# Harnett County Department of Public Health Site Sketch

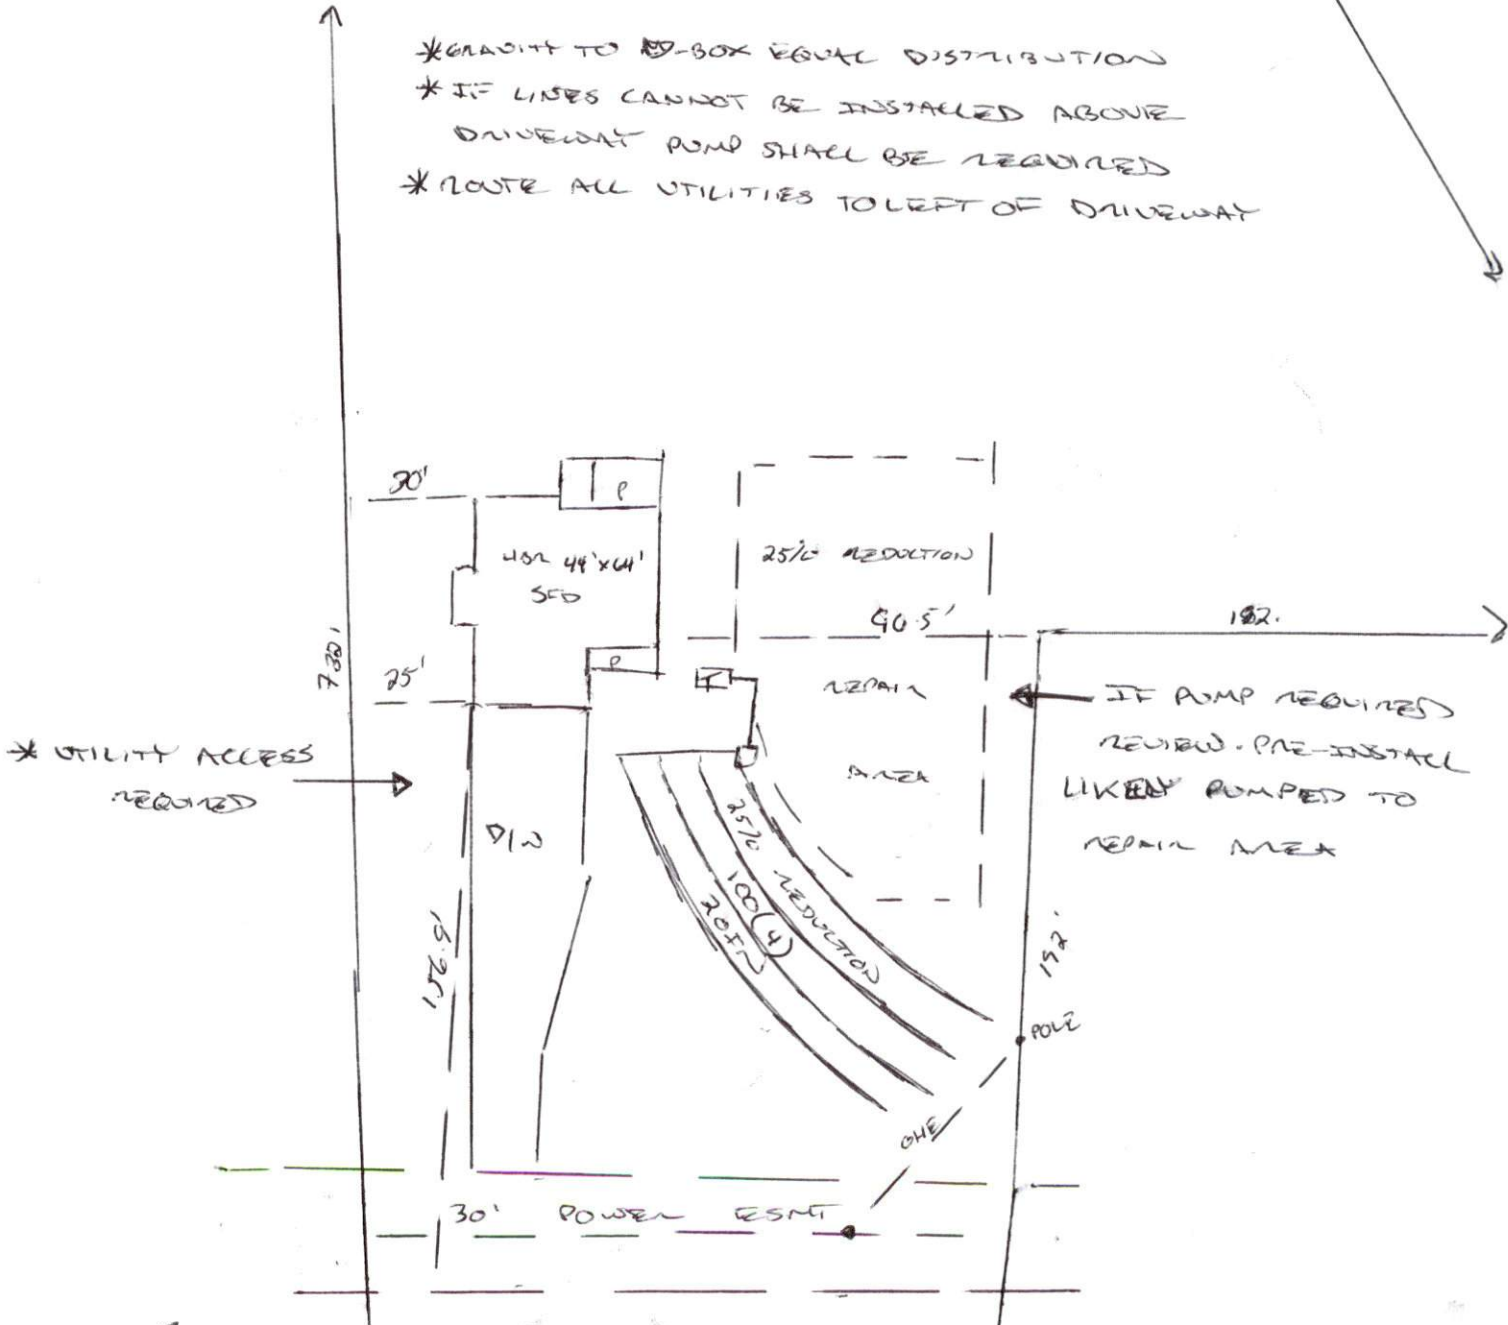
Show profile locations and other site features (dimensions, references or benchmark, and North)
